**Our Case Number:** ACP-323410-25

**Re:** Proposed Limerick City Greenway (UL to NTP)

# Planning Submission

**Proposed Limerick City Greenway (UL to NTP)**

SCALE @ A1 1:200	DATE OCT 2023	DRAWN KB	CHECKED BL	APPROVED PS
JOB No. 2535	CAD FILE PATH 2535 / 04 / DD / 01	DRAWING No. PD0012	REV.

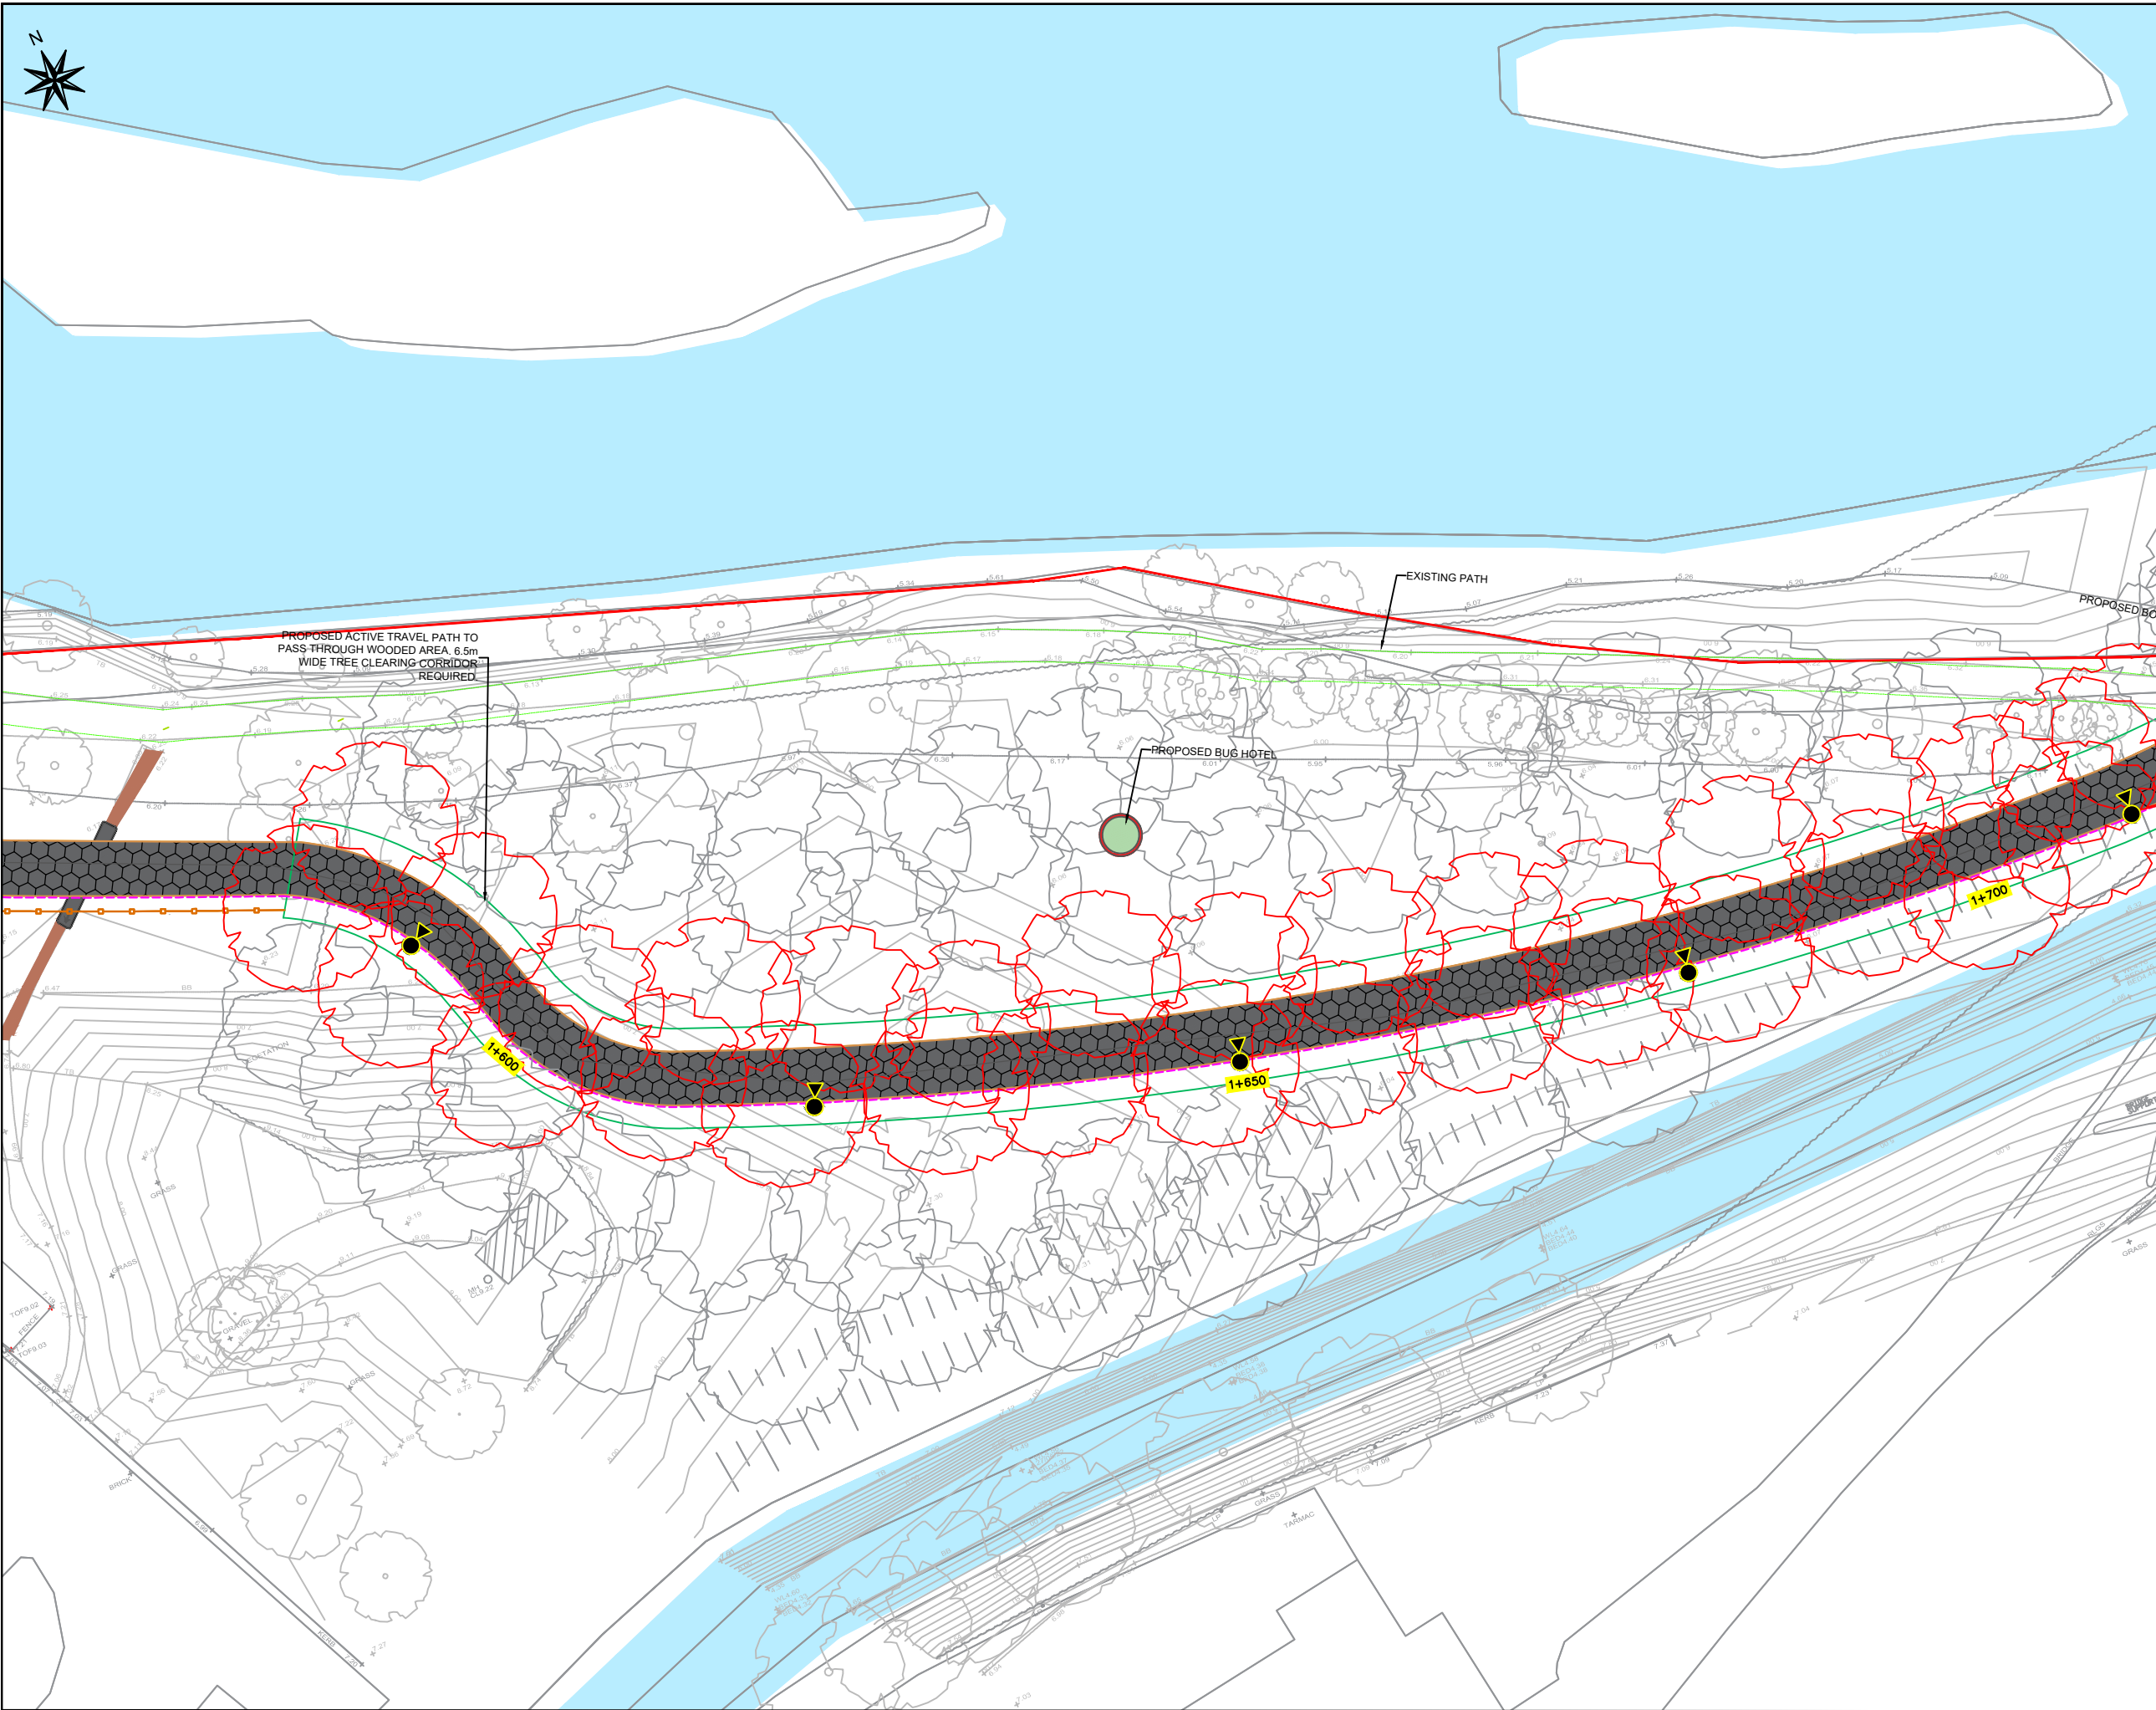
- 3.3.1 Plate 8 above is an excerpt of drawing no. PD0013 which illustrates the new path to the west of the Living Bridge (CH1320 to CH2180). Section 6.2.9 of the Planning Application Report notes that the proposed Greenway avoids an avenue of mature beech trees in an area of Annex 1 Alluvial Woodland along the riverbank by diverting south of the existing gravel path (@ CH1420) to immature Birch trees where a 6m wide avenue of tree clearance will be required to construct the proposed Greenway.

- 3.3.2 However, the trees to be removed, of which there is a significant quantum, have been characterised as being of moderate quality by the project Arborist, i.e., they represent *'Trees present in numbers, usually growing as groups or woodlands, such that they attract a higher collective rating than they might as individuals; or trees occurring as collectives but situated so as to make little visual contribution to the wider locality'*. Figure 6-102 of the Planning Application Report, excerpt in Plate 9 below, illustrates the area of moderate quality trees to be removed.

- 3.3.3 The removal of existing trees to facilitate the preferred option does not appear to be justified in this context. No alternative that avoids the removal of these mature trees is presented in the alternatives assessment. The environmental benefit of this section of the preferred route relative to the loss of this quantum of trees, and the potential impact on the survival of the overall group of trees, is questionable.

- 3.3.4 In this context, we respectfully request the Commission to ask the applicant to submit revised proposals for the section of the proposed development to the west of the Living Bridge that utilises the existing path (Plates 10-11), with a modified route closer to the riverfront that mitigates any impact on the existing Alluvial Woodland, as presented in Plate 12 below:

Sheet 14 of 32				
SCALE @ A1 1:200	DATE OCT 2023	DRAWN KB	CHECKED BL	APPROVED PS
JOB No. 2535	CAD FILE PATH 2535 / 04 / DD / 01	DRAWING No. PD0014	REV.

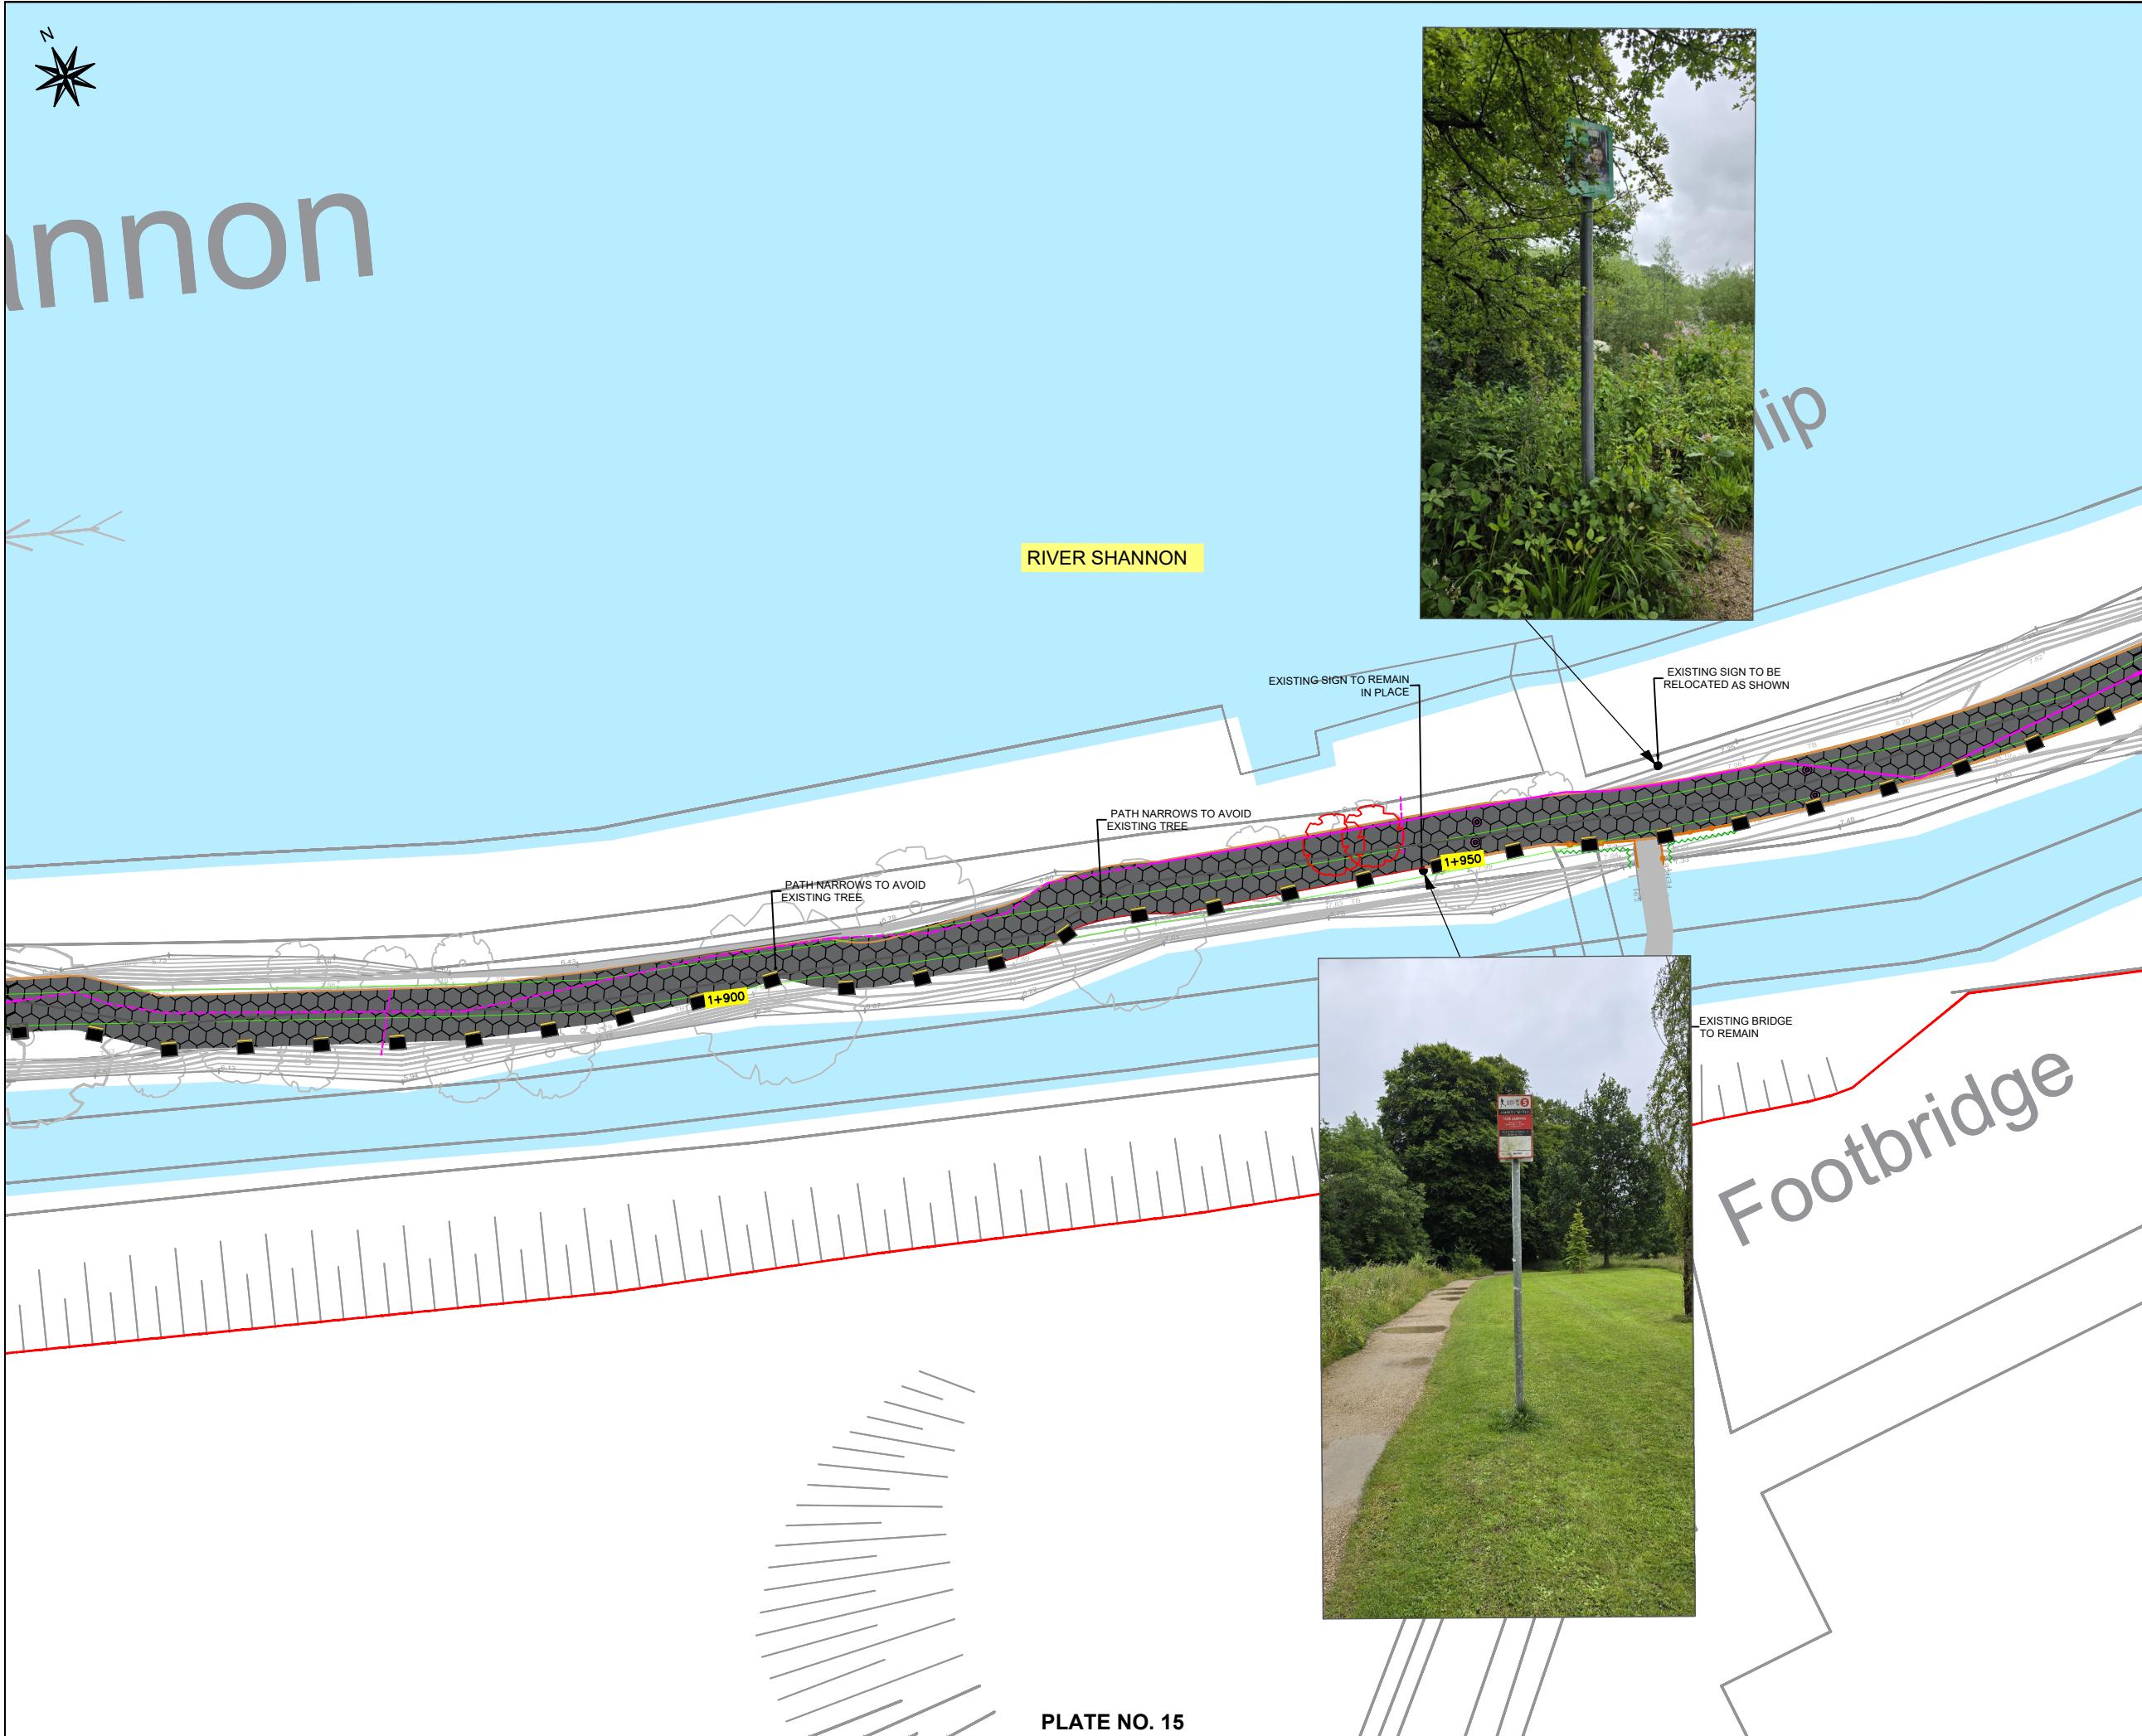
- 3.2.1 Plate 1 above is an excerpt of drawing no. PD0011 which illustrates new path, which diverts away from the existing path through an existing wooded area to the south of the existing Fisherman Cottages.

3.2.6 There does not appear to be an environmental reason to rule out the alternative option of using the existing path to the front of the Fisherman Cottages. It is considered that the lack of environmental assessment of this reasonable alternative is a weakness in the application. The removal of existing trees to facilitate the preferred option does not appear to be justified in this context. The provision of replacement planting to compensate for the removal of these trees is also, therefore, not justified. In addition, the proposed greenway bisects a meadow on University land, which is an established amenity area, and contains mature trees. This section of preferred route appears to have a higher potential for environmental impact than the alternative existing route and is therefore not in the interests of the proper planning and sustainable development of the area. In addition, the proposal to instal a berm to address concerns raised by residents of the Fisherman Cottages in relation to flooding can be facilitated in the alternative existing route.

3.2.7 In this context, we respectfully request the Commission to request the applicant to submit revised proposals that either:

- Incorporate the use of the existing route to the front of the Fisherman Cottages for that section of the proposed development (the preferred option from the University's perspective), or
- Incorporate the use of the existing route along the Millstream, connecting back to existing University roads, avoiding the meadow altogether.
